Online Comment

Application H04-0538-22
Location THOMAS COWLEY HIGH SCHOOL SCHOOL LANE DONINGTON PE11 4TF
Proposal Creation of tarmac area

Name Diane Fairchild
Address Conservation Assistant (Tree Preservation) Planning & Development

Site plan.

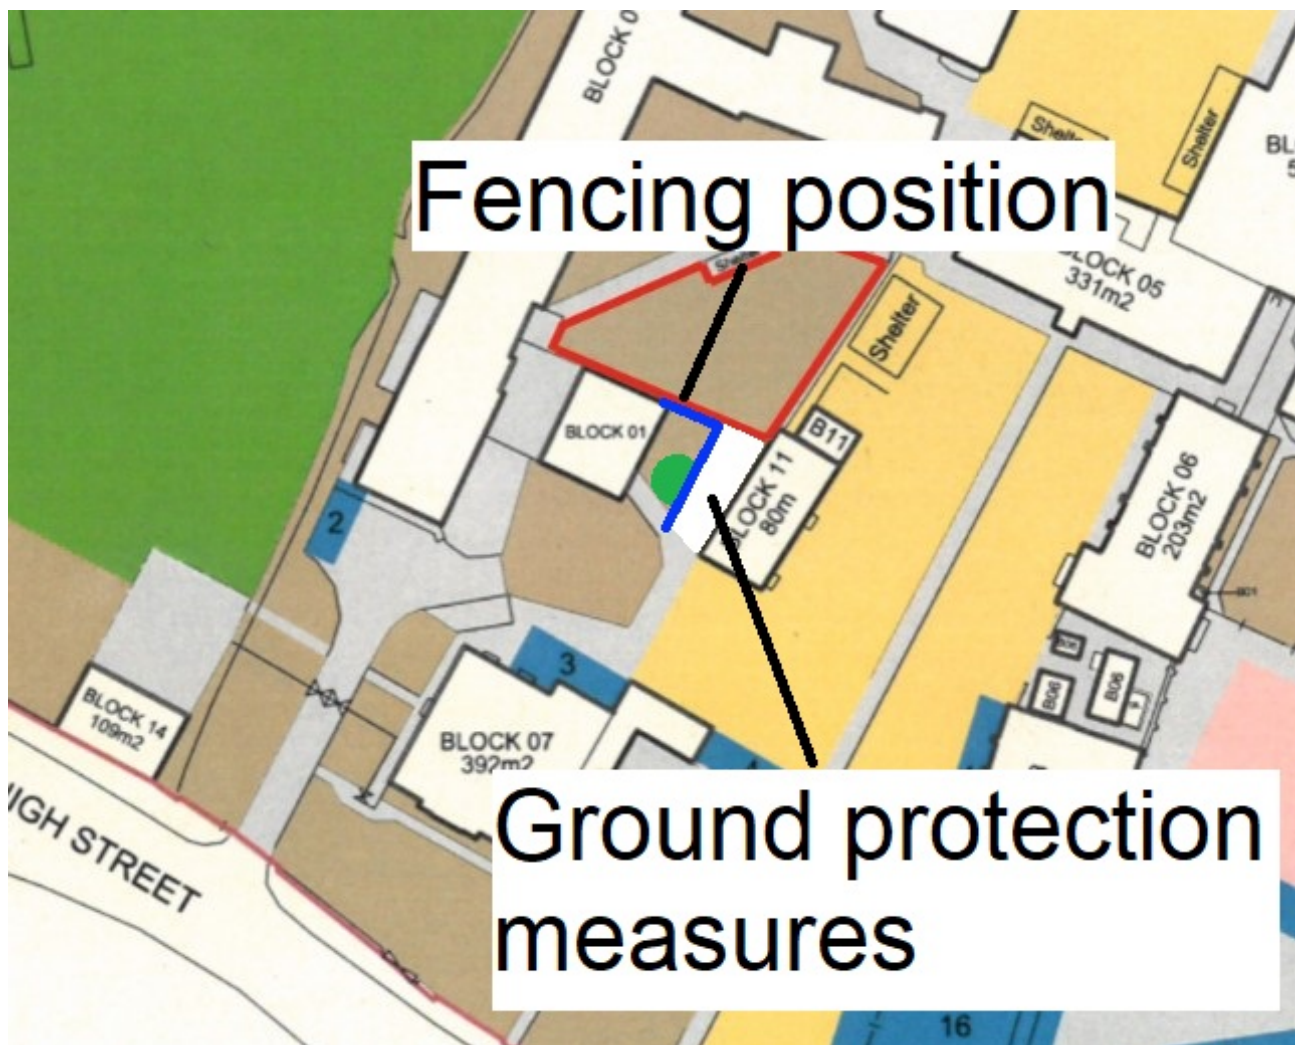
Two Conservation Area trees to be affected.

Cherry to be removed, could not readily see an explanation in the application.

Could easily be incorporated into the design and retained to visually enhance the area.

Crown could be lifted to pre-empt any visibility concerns. It is noted that a replacement is to be planted elsewhere to compensate for the proposed loss of the original.

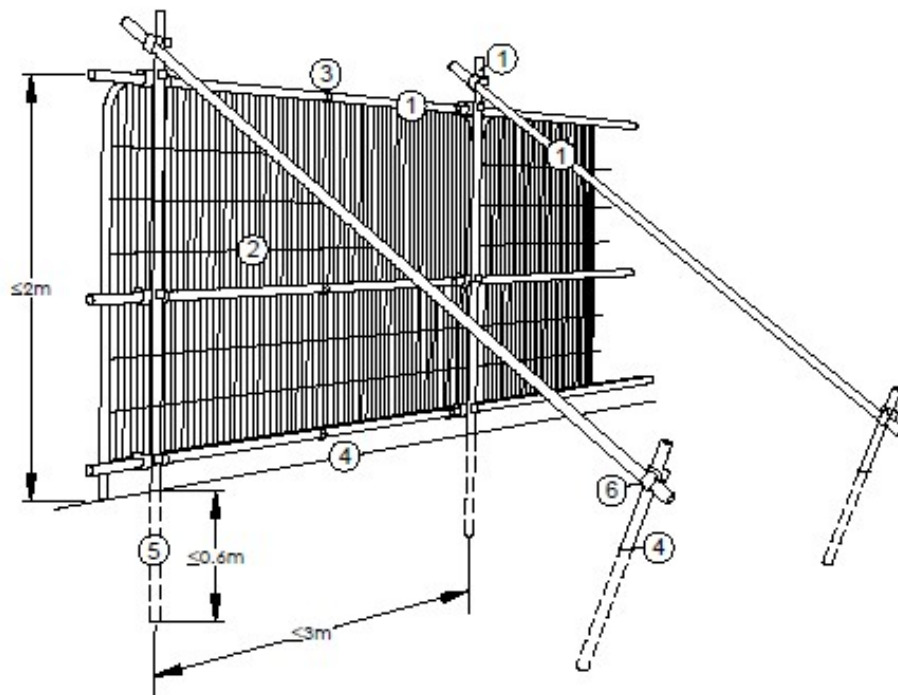
Silver birch to be retained. Should be protected as in Tree Report PRIOR to construction works commencing.

Some encroachment into Root Protection Area. Detriment should be minimised by using porous tarmac.

Noted that propose to crown raise to 3m.
